Our Ref: FG/49/12/

1st June 2012

Loft extension to rear & dormer for additional bedroom. Front roof to be gable end
60 Langbury Lane Ferring

Thank you for your internet comments made on 31st May 2012 and recorded as follows:

Proposed West Elevation

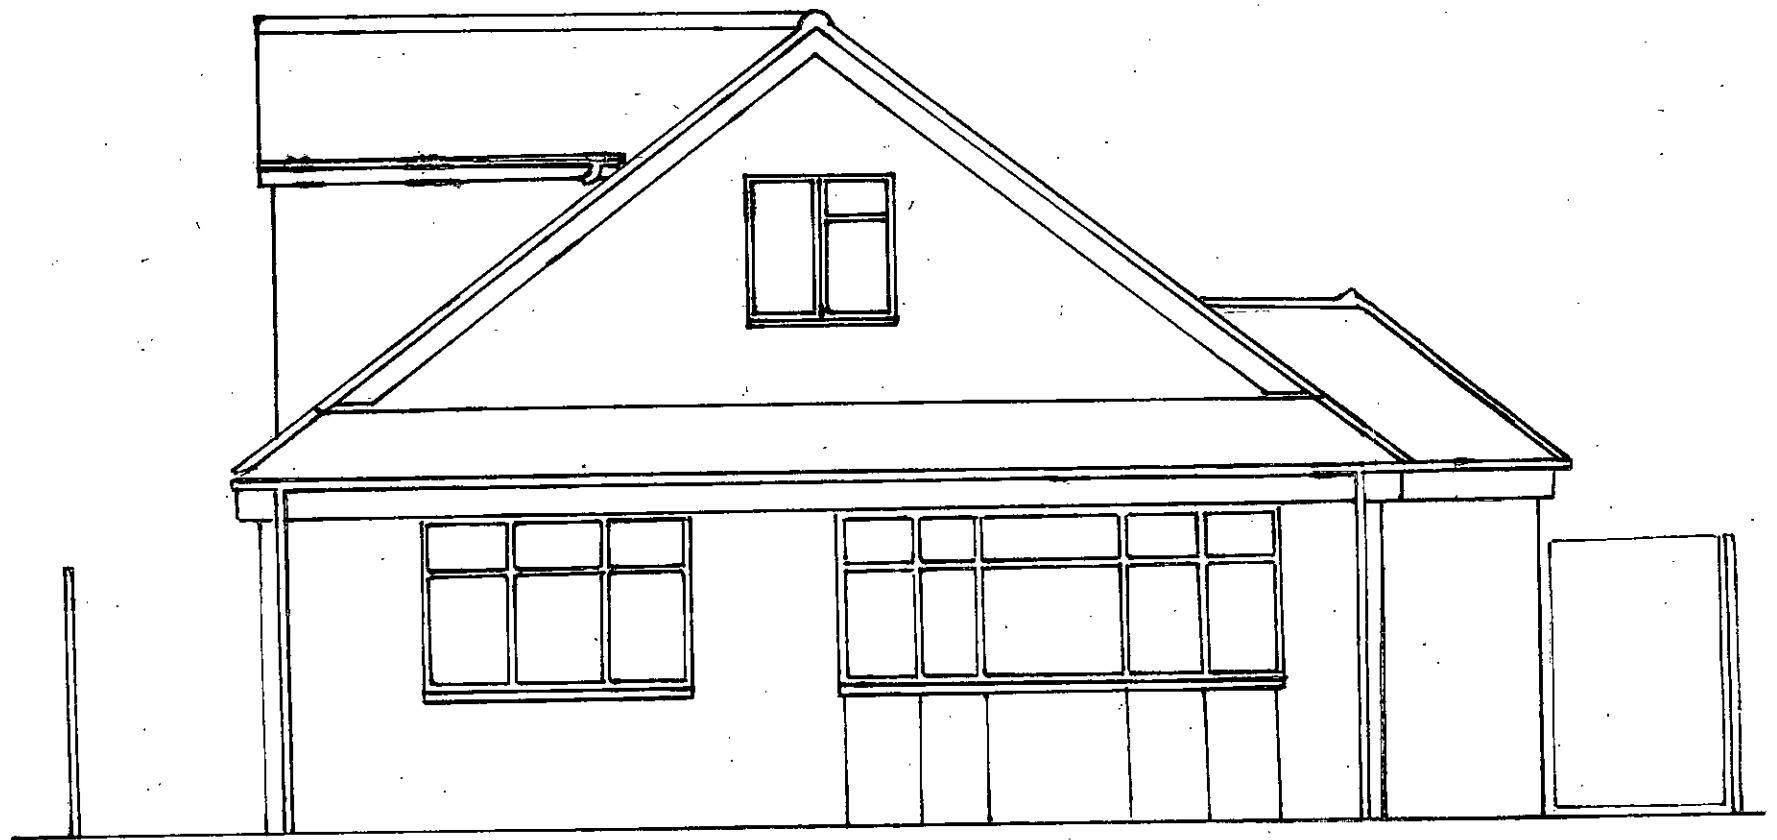
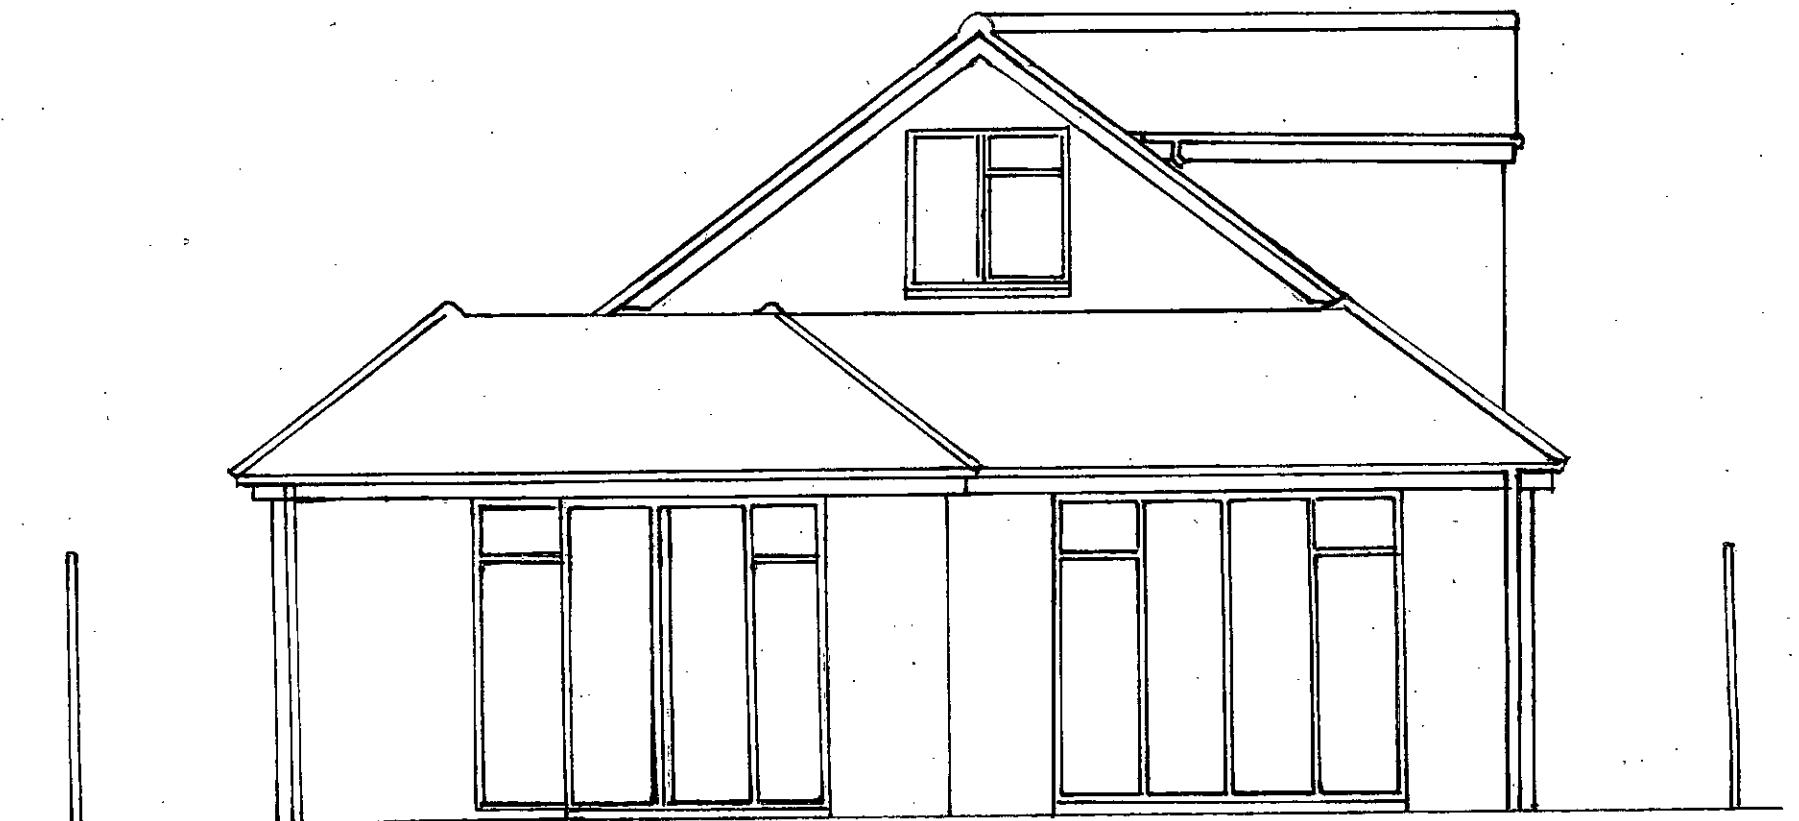
OBJECTION. The proposed roof alterations and changes to the dwelling are substantial and, by virtue of their design, form and scale, they would not be visually integrated with the existing dwelling or visually subservient to the main building. This plan would alter the simple character of the existing dwelling and would be out of keeping with the character of the street scene. The proposal is thereby contrary to the provisions of policies GEN7 and DEV19 of the Arun District Local Plan.
